REVISION RESPONSE LETTER

RE: 1000, LLC
Site Development Plan
File Number PPR-17-026

DATE: August 24, 2017

1 NORTH-WEST ELEVATION
SCALE: 1/4"=1'-0"

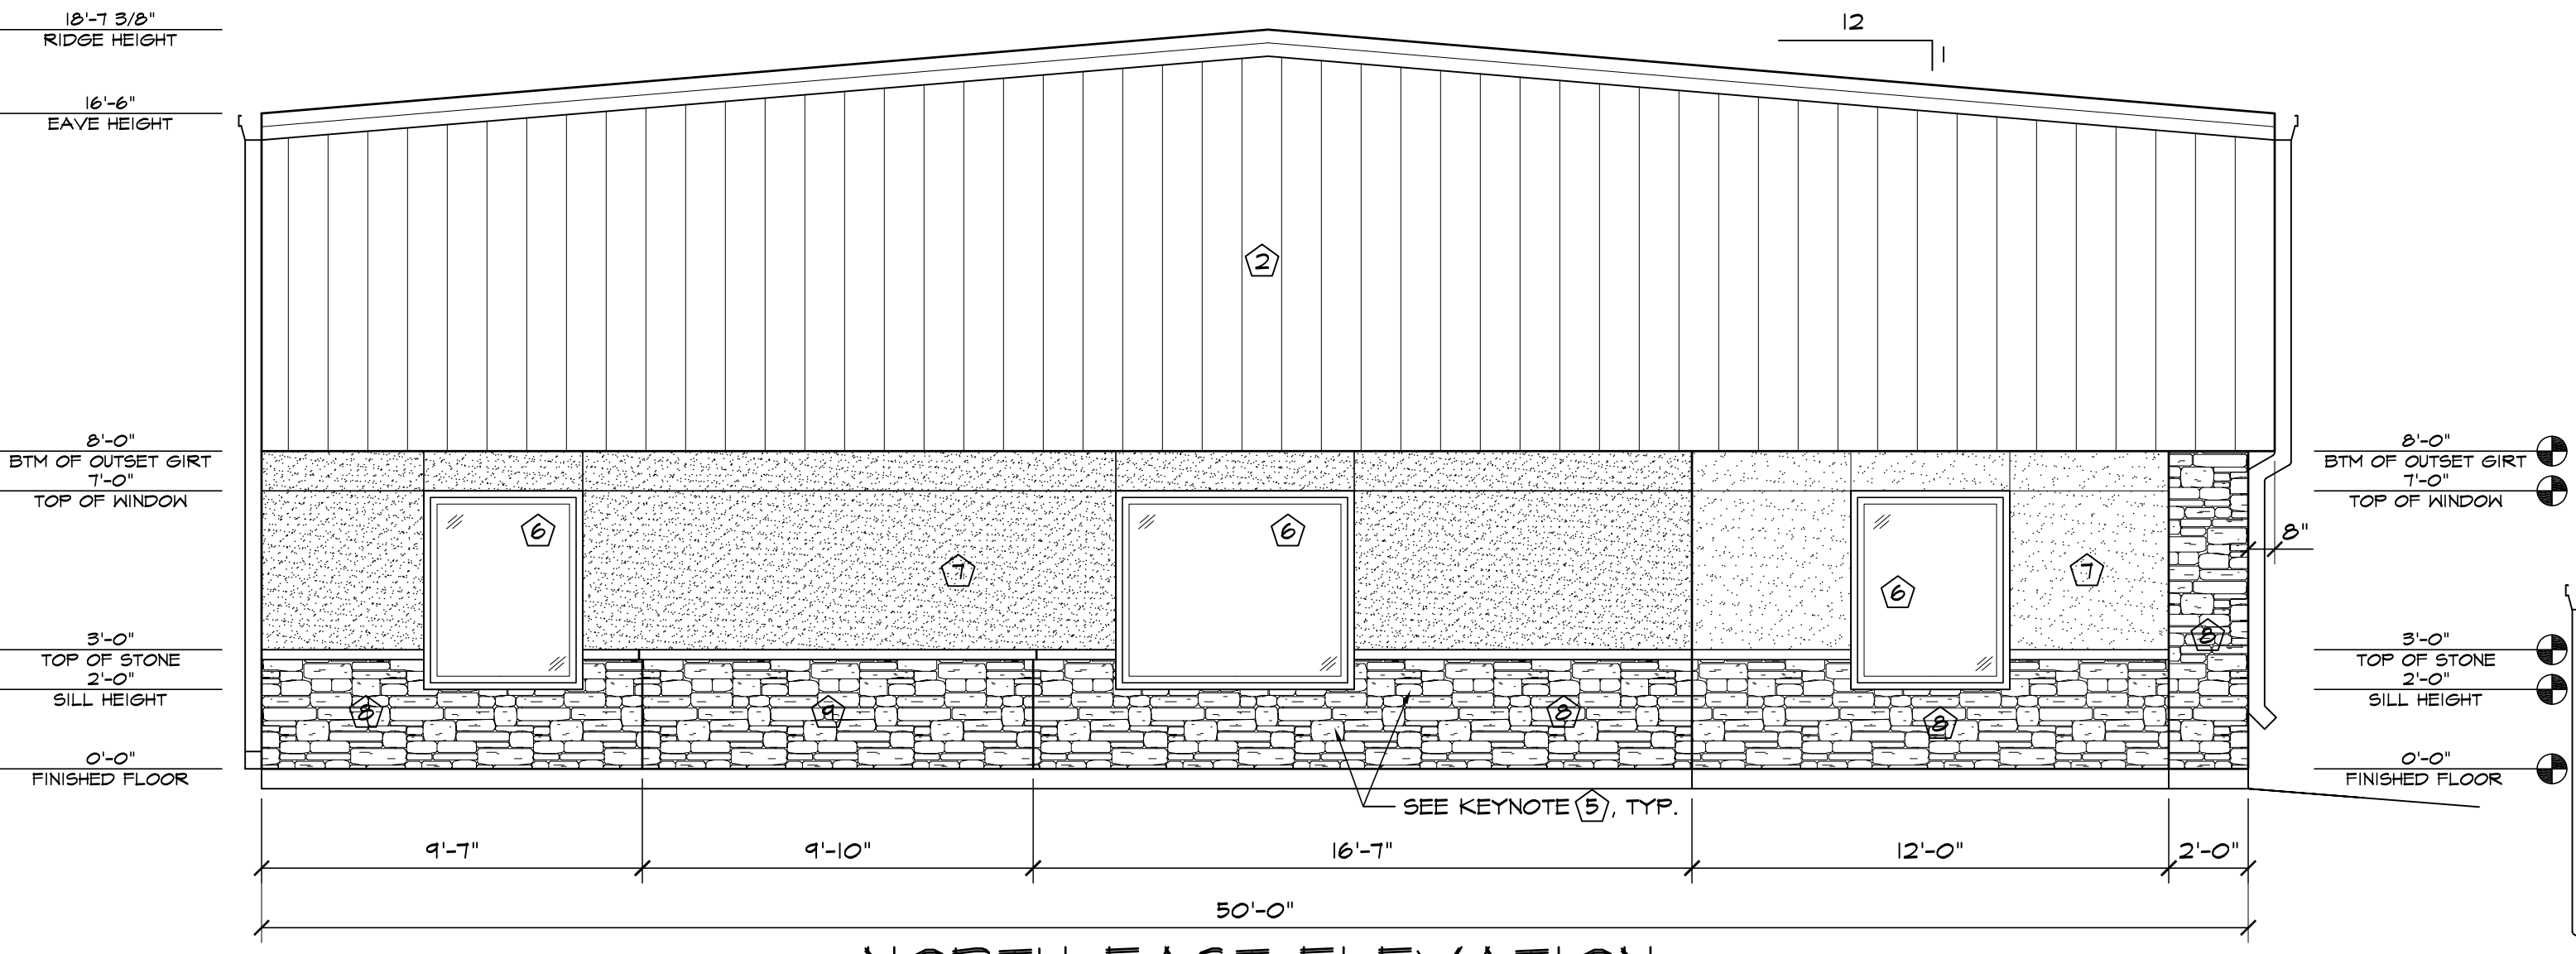
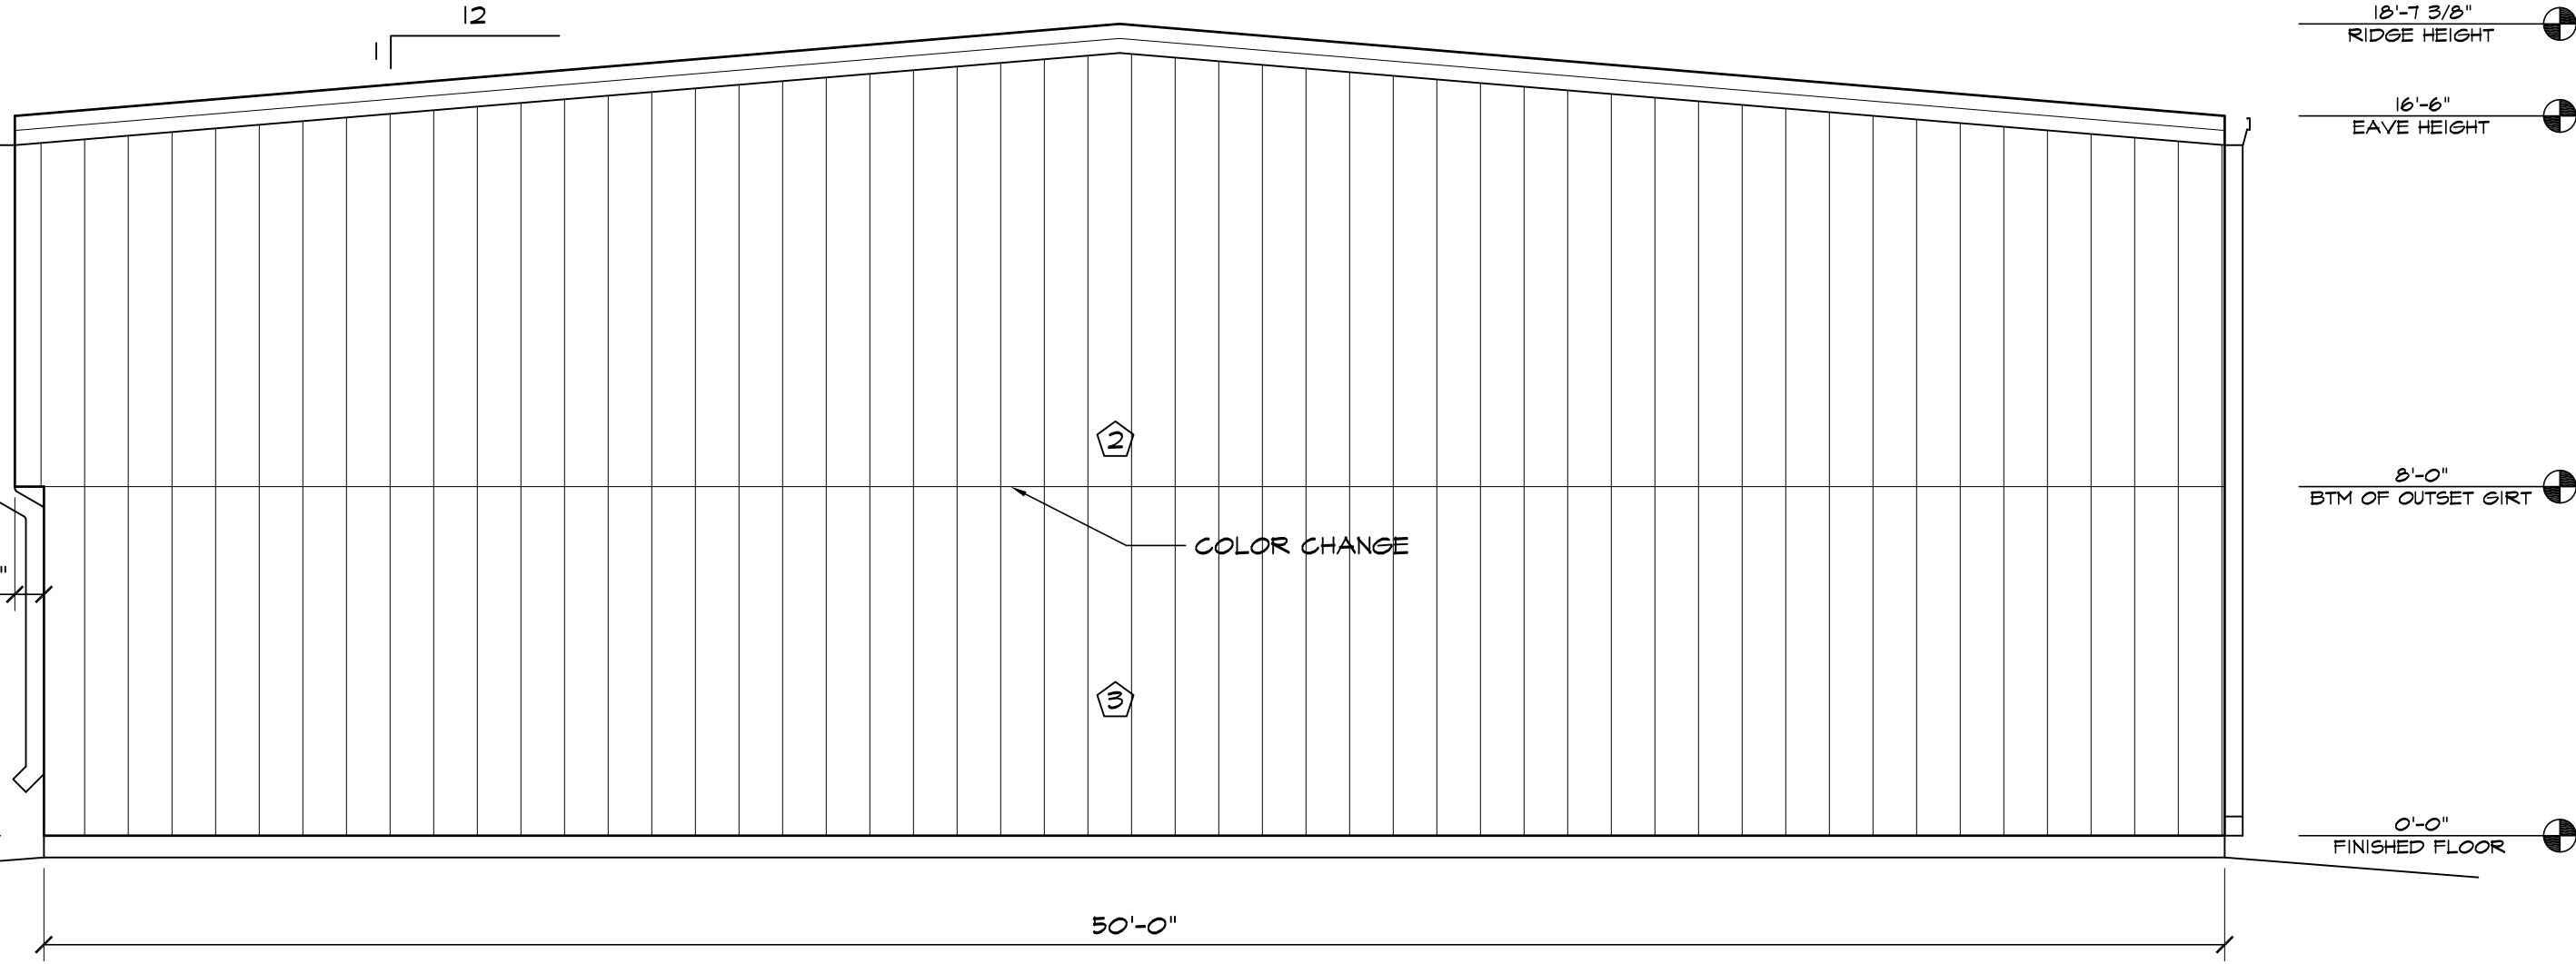
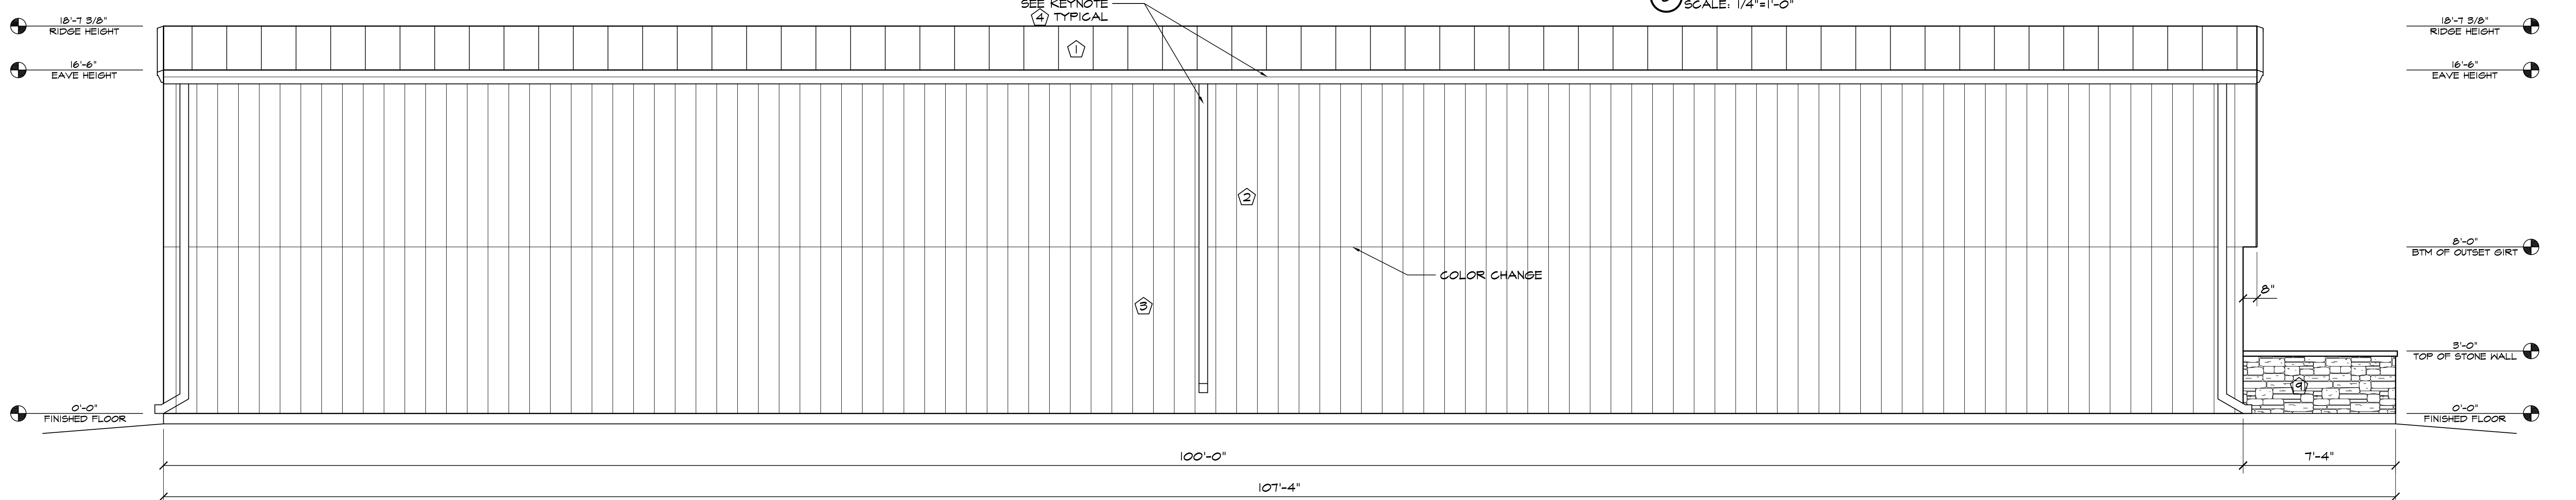
Comment 1: Engineering redline comments on the following pdf documents will be uploaded by the project managers: Building Elevation, Drainage Letter, Grading and Erosion Control Plan, and SWMP. All comments have been addresses to the Drainage Letter, GEC Plans, Financial Assurance, SWMP and O&M reports as requested.

5 DRIVEWAY DETAIL
NOT TO SCALE

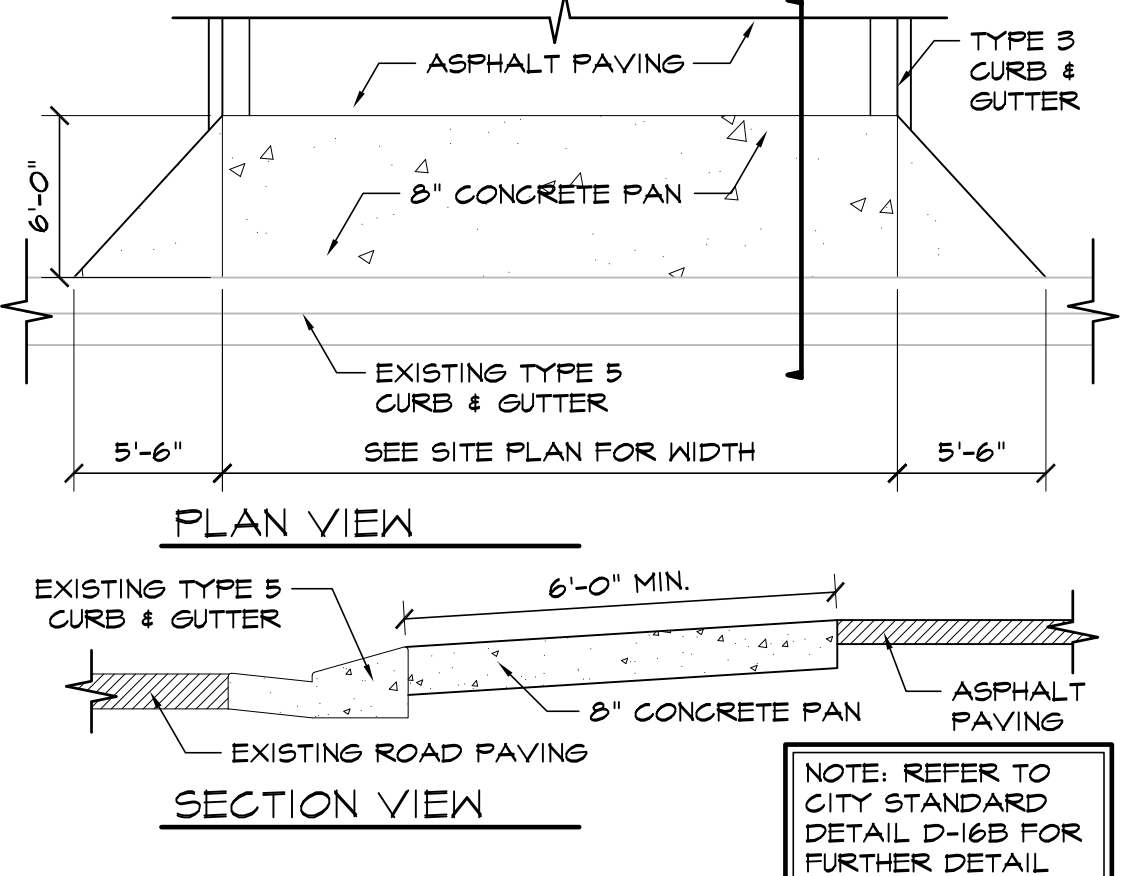
- **Driveway detail: we have been using this detail since CBP started in 2006. In addition, EPC has approved 3 other projects recently that this comment did not come up even though it's the same detail. Plus, since this is accessed off of a private road the exact details should not matter...**
- **In regards to the parking detail. I believe we clearly shown our intent. If we were to use compact spaces then we would have a "C" in the parking space just like the handicap symbol to indicate that parking. In addition, under the Project Information, under required parking spaces, we list how many spaces of H/C, standard and compact. As our plan indicates we have 0 compact spaces. I hope this clears this up for you.**

1 SITE PLAN
SCALE: 1"=20'-0"

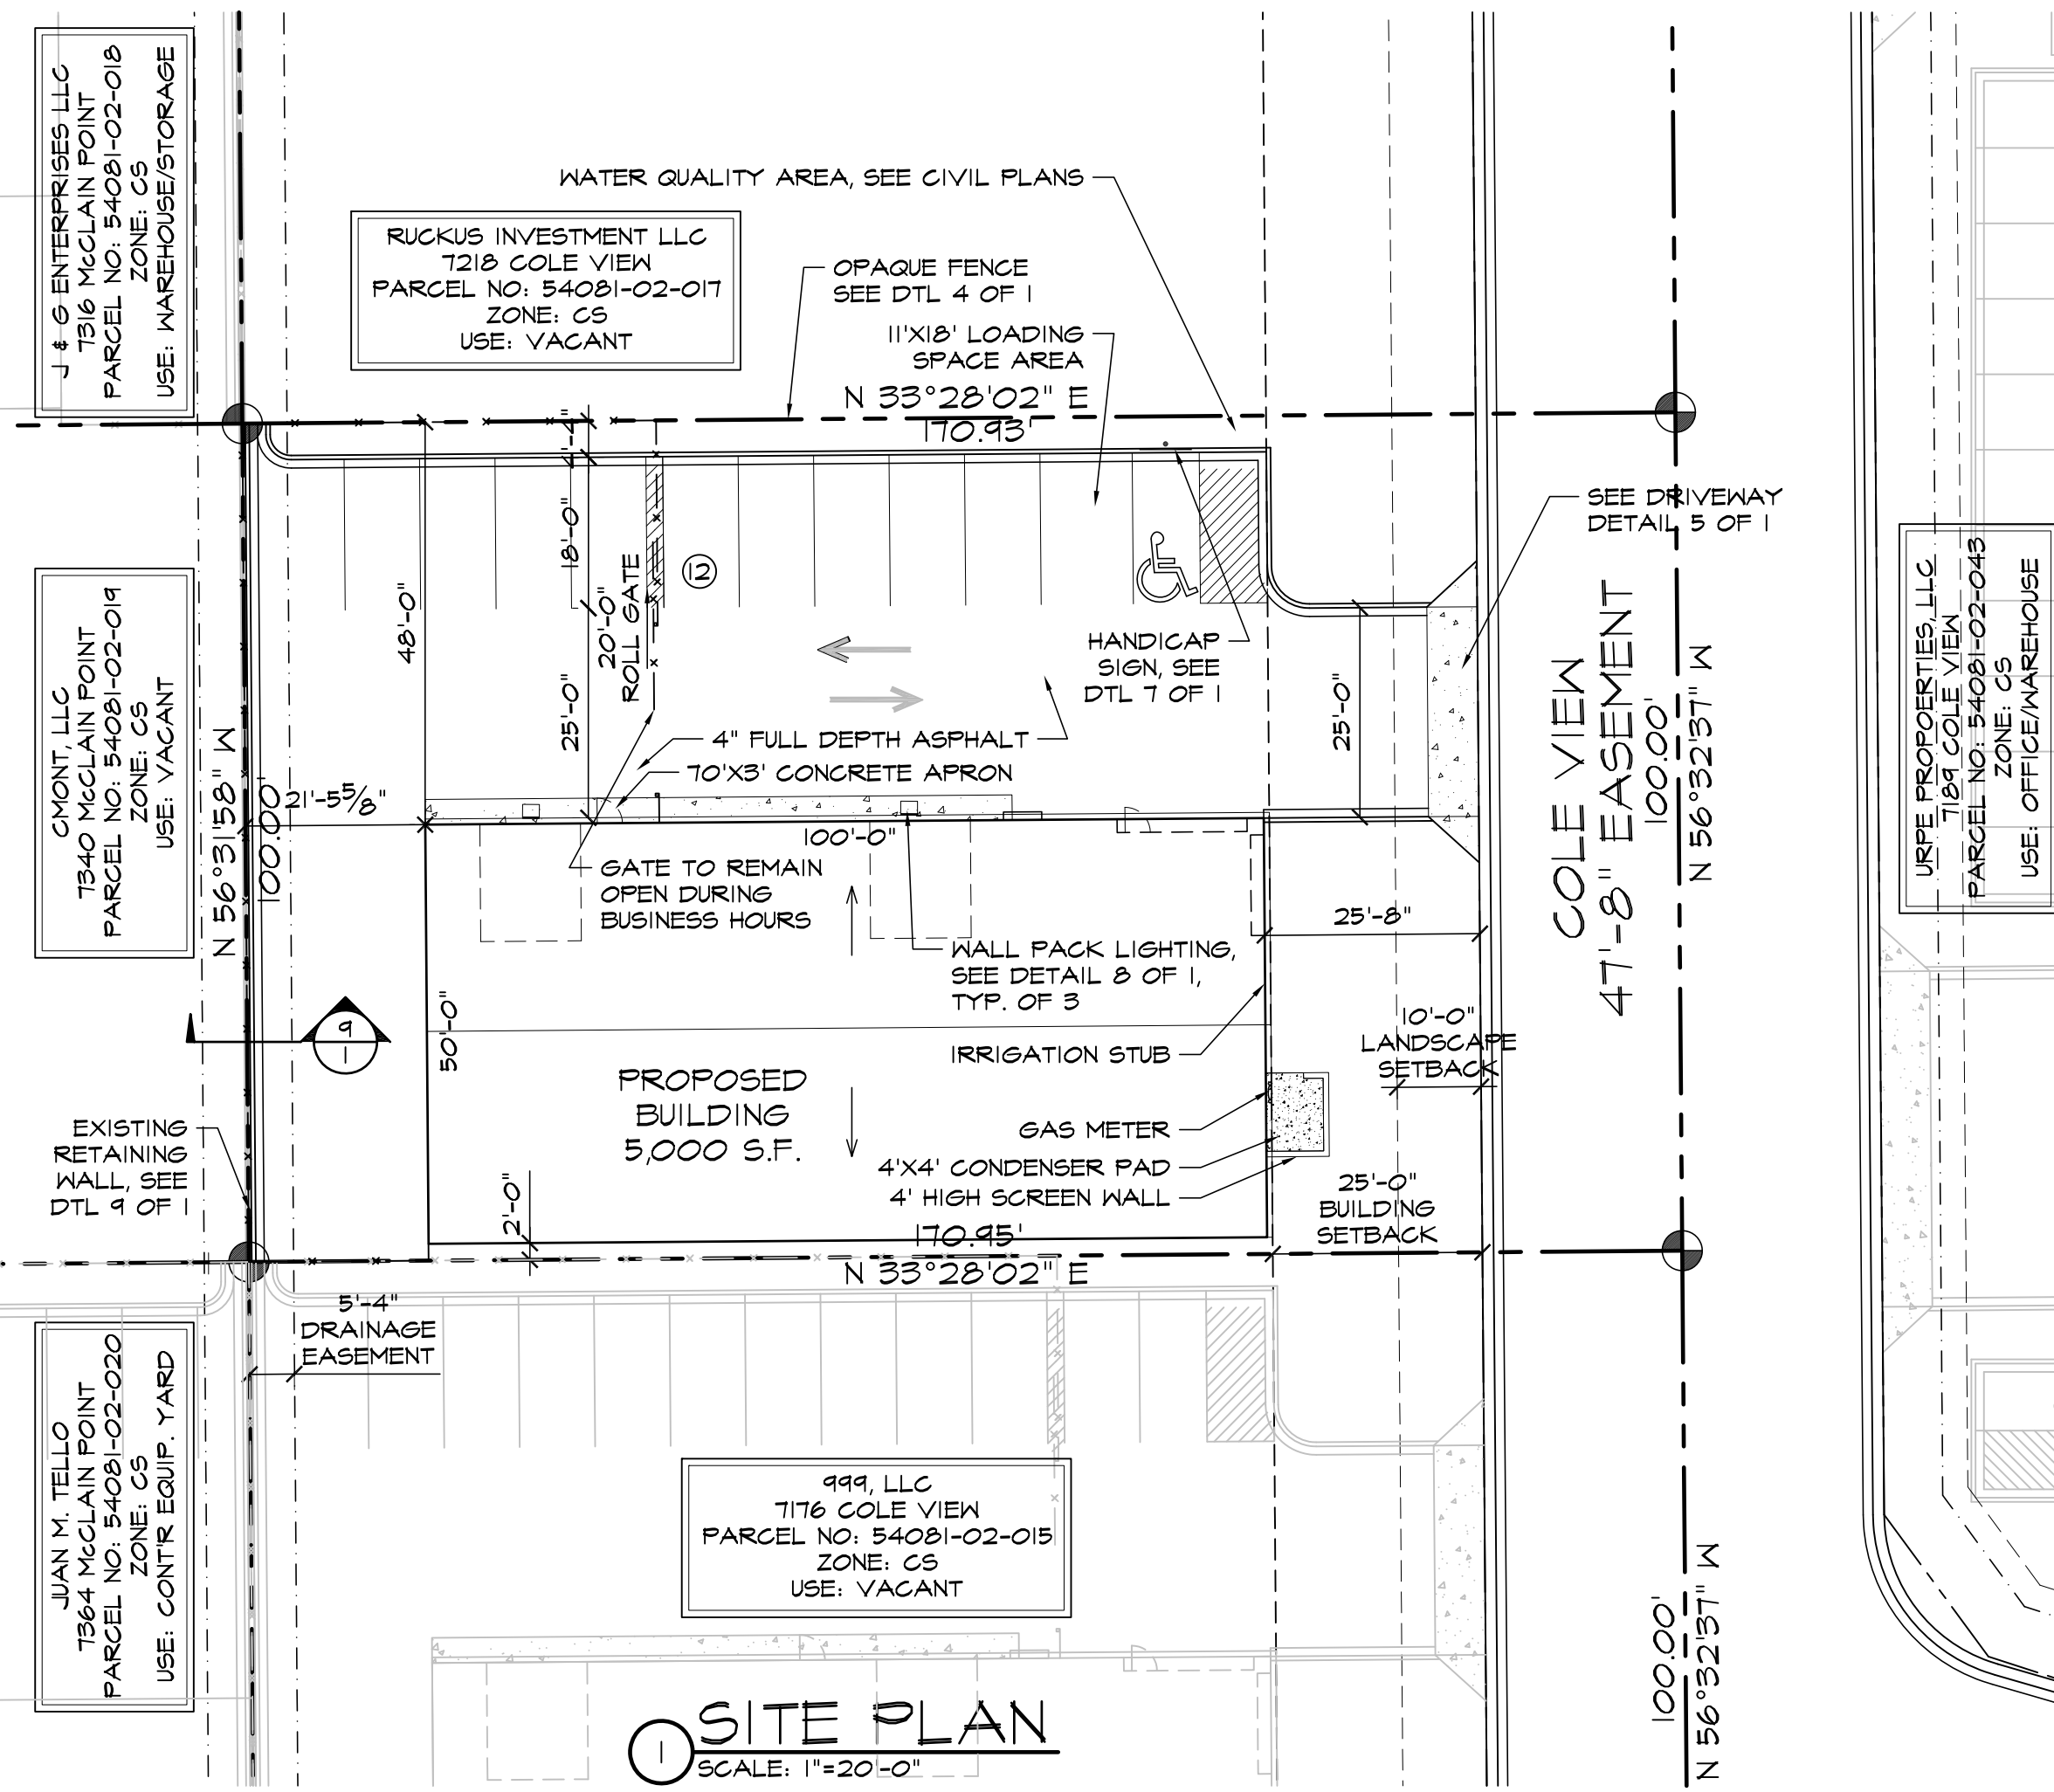
1. Please contact the electric and gas field engineer assigned to this area for further coordination (Ginny Halvorson, 719-668-5567, ghalvorson@csu.org) prior to any construction. **Noted**
2. Label and depict all existing easements in Cole View Way (Reception #207712506). **Rec number has been added**
3. Label all existing and proposed electric and gas utilities lines to include the existing electric vault located in the northeast corner of the property. **Vault has been noted on the plans**
4. Depict proposed electric meter location. **Elec meter has been noted on the plans**
